Application No: CM/27/20/DOC
Site Address: Langford Horsemere Green Lane Climping BN17 5QZ
Description of works: Approval of details reserved by condition imposed under ref CM/64/19/PL relating to Condition Nos 3 - materials & finishes, 4 - Construction Management Plan, 9 - pre-commencement site meeting, 19 - foul drainage and 20 - contamination

Thank you for your internet representation made on 18th September 2020 which has been recorded as an objection with the comments as follows:

PROPOSED DEVELOPMENT PLAN
Scale 1:500

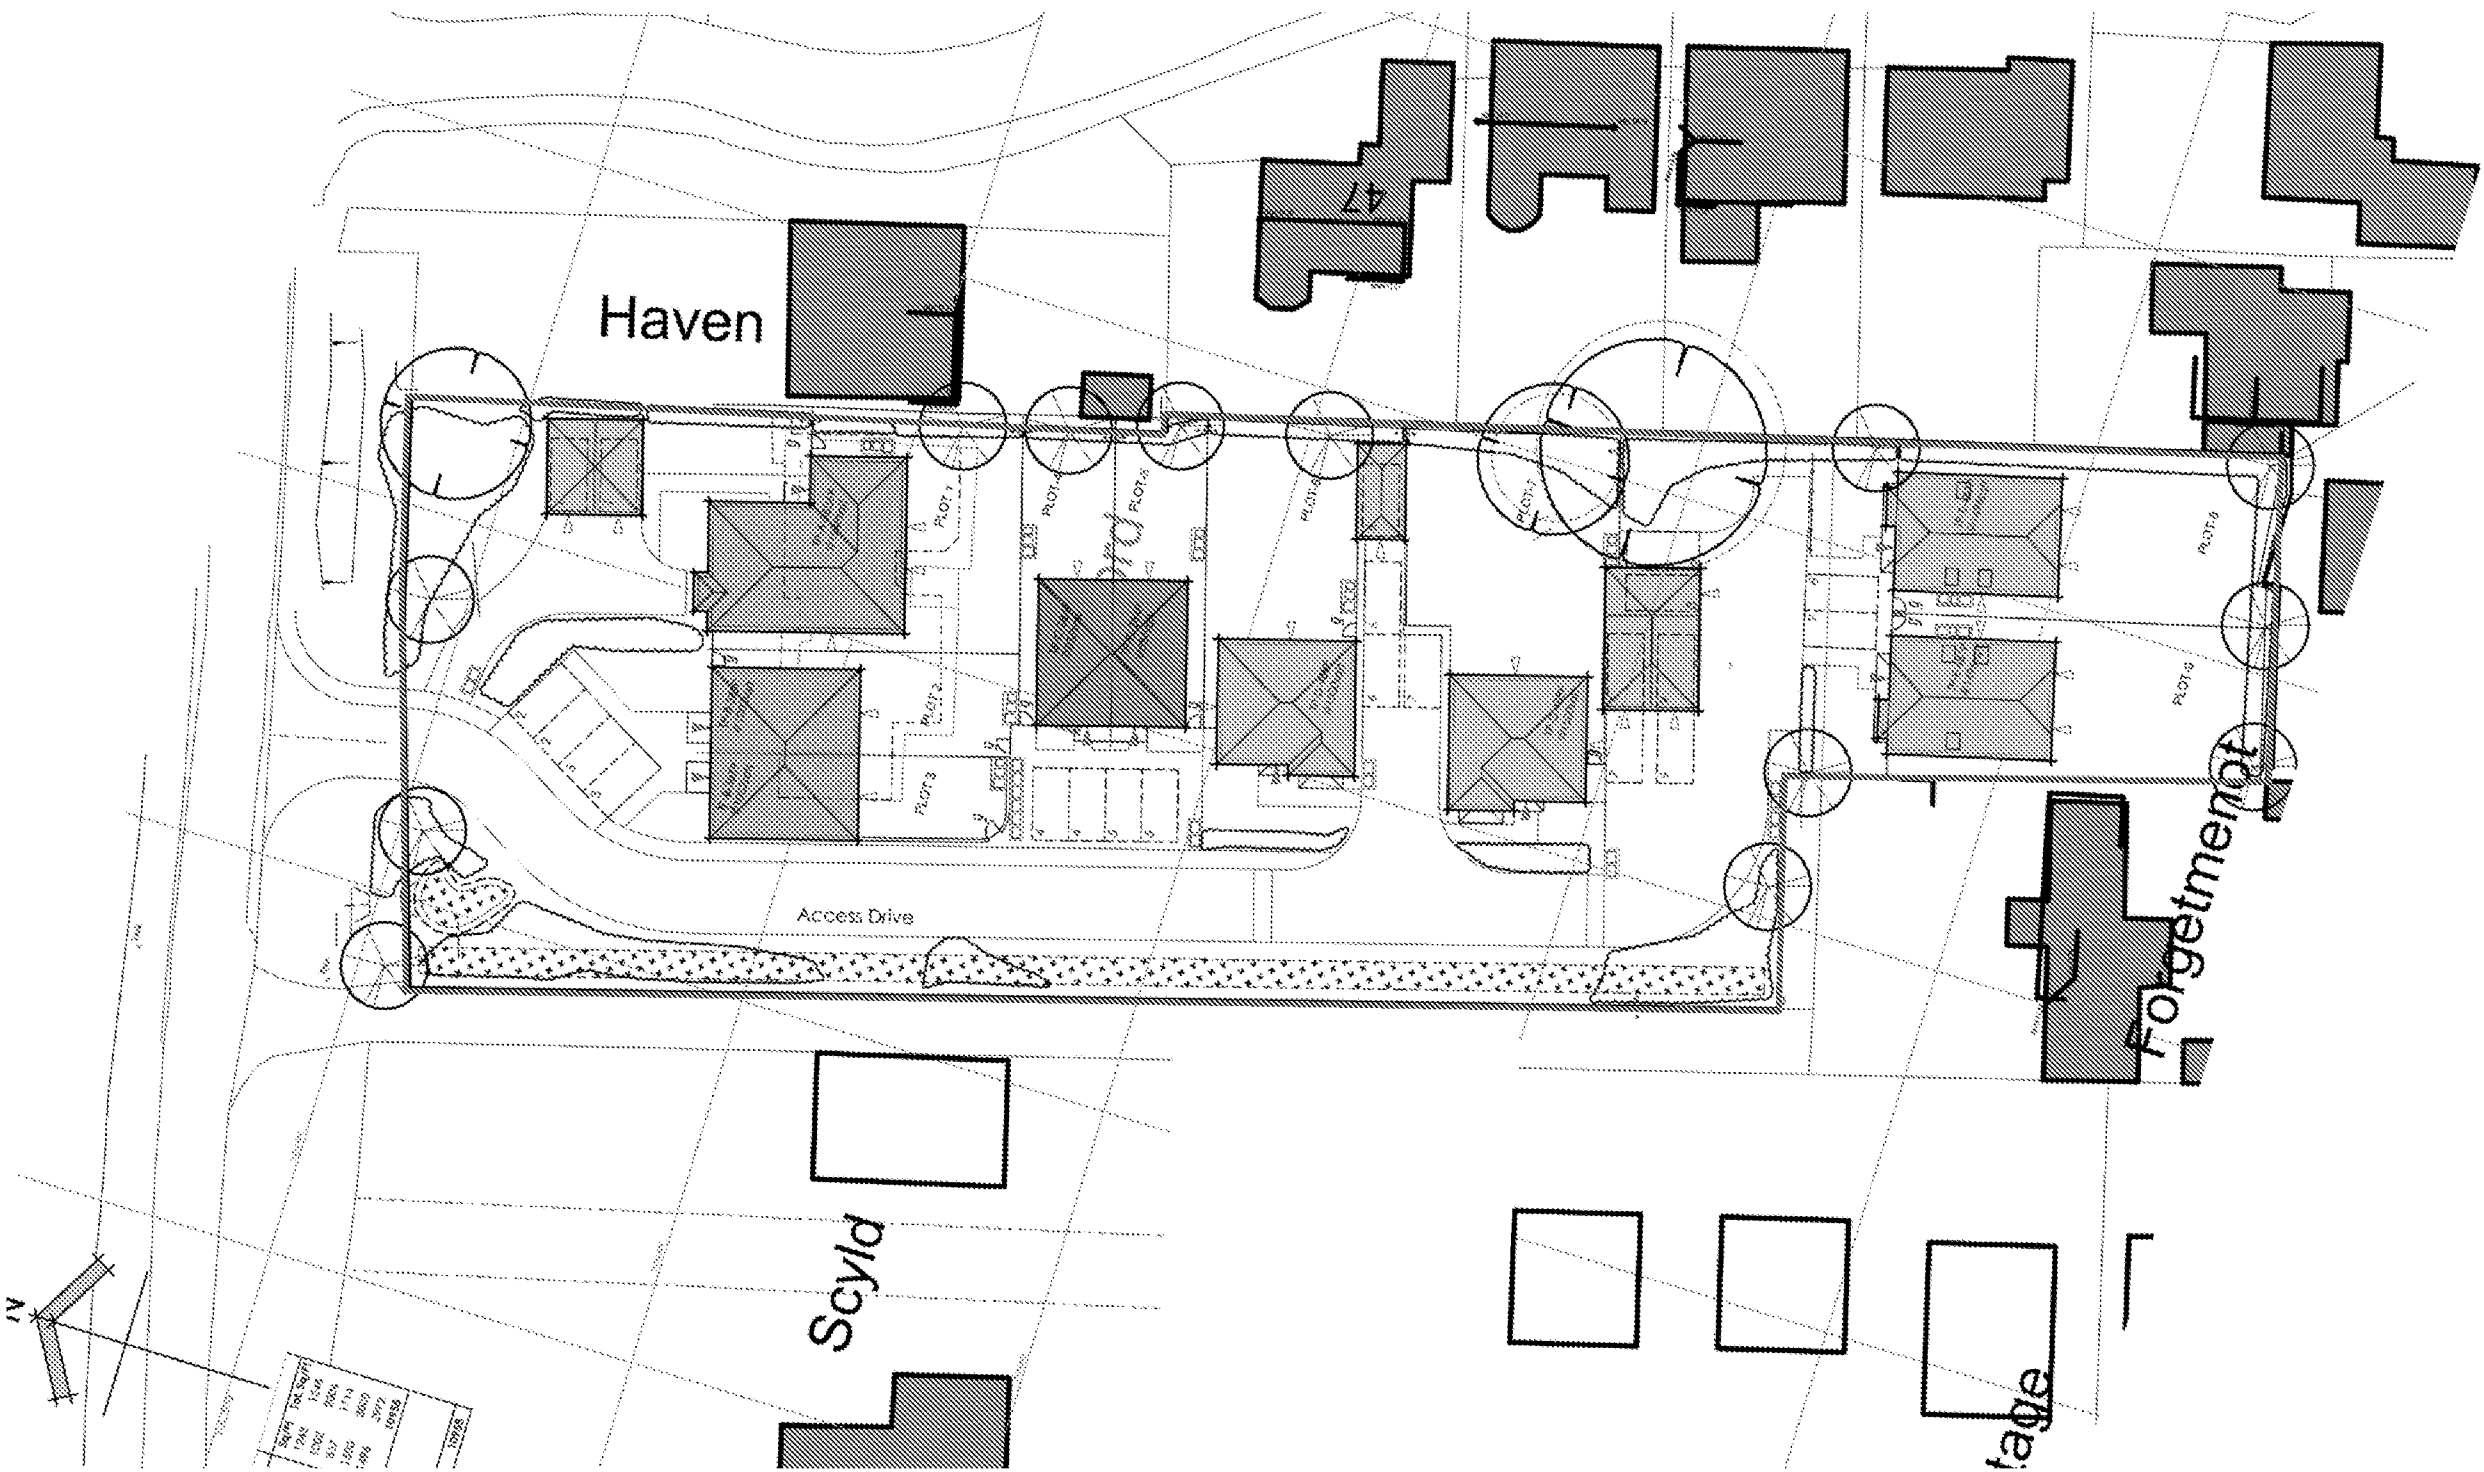
I have just read the Site investigation report dated 16th September and under section 10 - Assessment of soakaway drainage it states that due to the low permeability of the soil "soakaway discharges should be located at least 5m from proposed or existing building foundations".

The plans indicate a proposed building 2.3m from my boundary. My property discharges to a soakaway next to the boundary. Consequently I have a concern the foundations of the plot 8 may be too close to my existing soakaway.
